Town & Country Planning Act 1990 (as amended)
Town and Country Planning (Development Management Procedure) (England) Order 2015
Application for approval of matters reserved by condition imposed under EP/63/16/PL relating to
conditions 9 for surface water drainage & 10 for SUDs information.
Bradbury Hotel Station Road, East Preston,

Condition Number 9

Arun District Council have decided to **REFUSE** details reserved by condition for the following reasons:

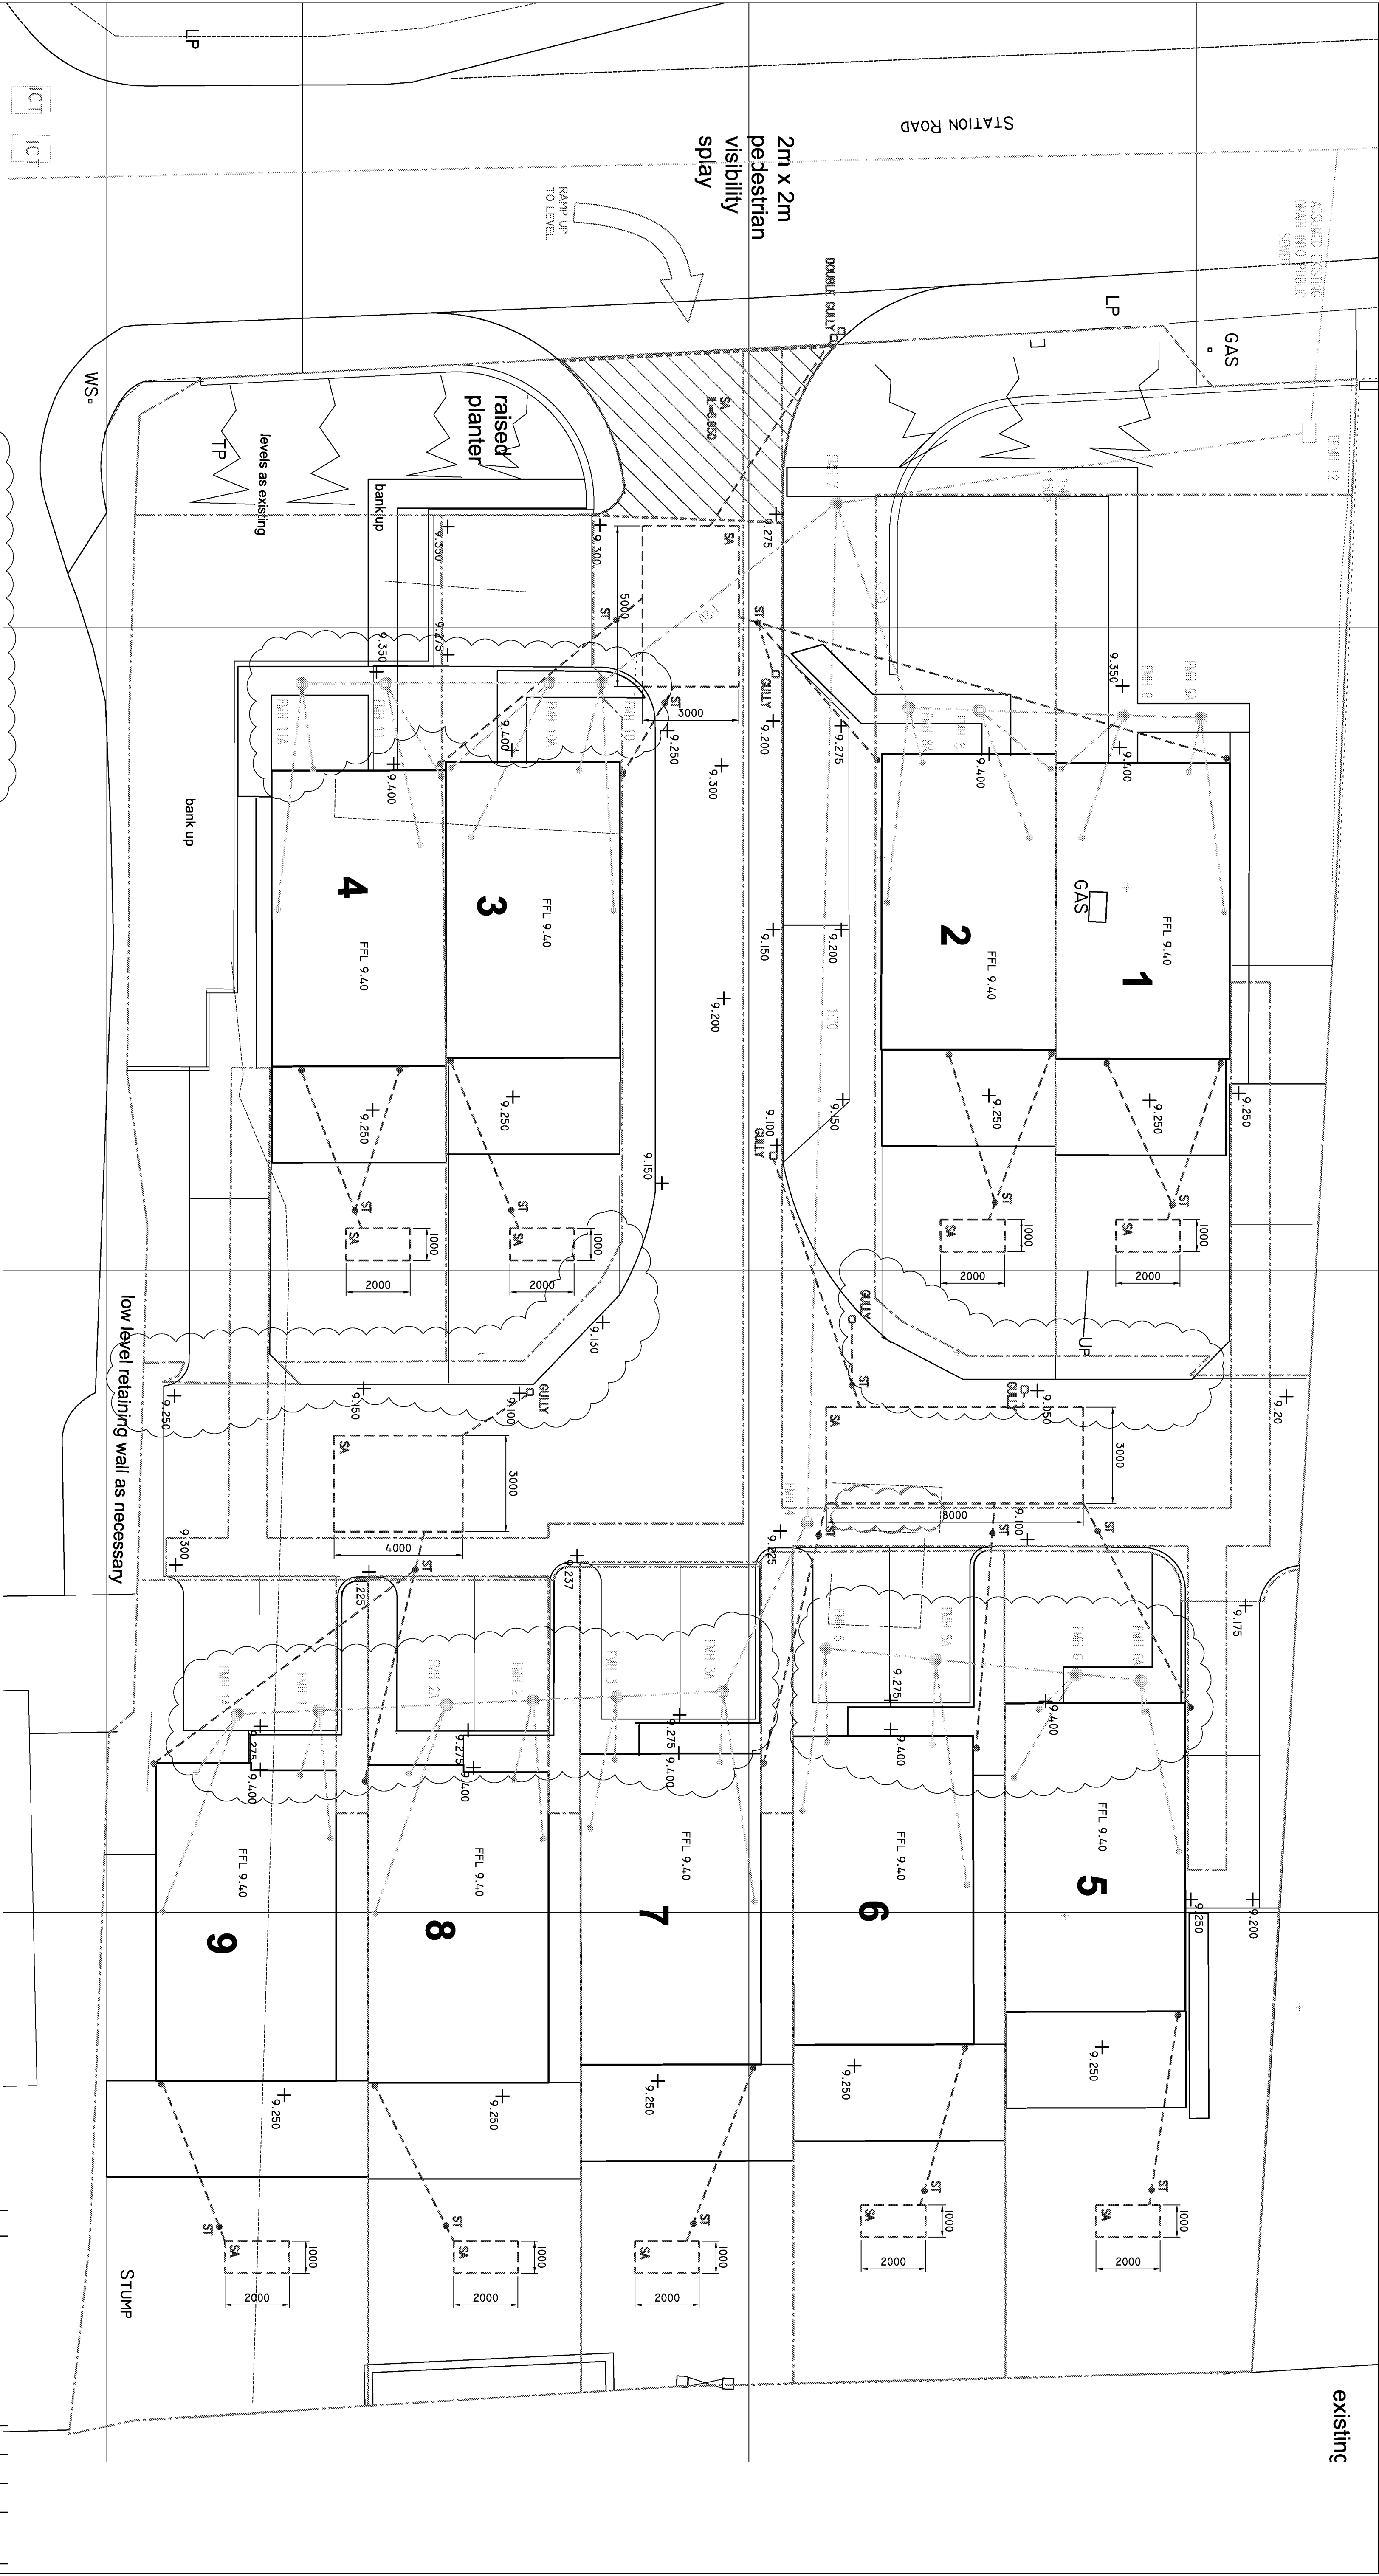
1. Undertake trial hole/s in plots 1 and 2, at location of proposed soakaways, when site conditions allow, to determine depth/existence of the gravel layer.
2. Undertake trial holes in plots 5 to 9 to determine depth/existence of the gravel layer.
3. I await the outcome of items 1 and 2 so the soakaway design can be discussed further.
4. Previous comments to be addressed; Microdrainage calculations - The structures modelled (apart from the 2 x 1m plan area soakaways) do not correspond to the soakaways detailed on docdeci

drawing WO1371-200 Rev C01, in terms of plan area. The calculations need to be resubmitted accordingly for each different soakaway plan area. This drawing needs to specify the invert levels of the pipe entries into each soakaway, soakaway base and cover levels, top of crate levels. The levels used in the calculations also need to correspond to the relative levels used on the drawing, as currently they do not.

5. Provide silt trap manhole construction detail.
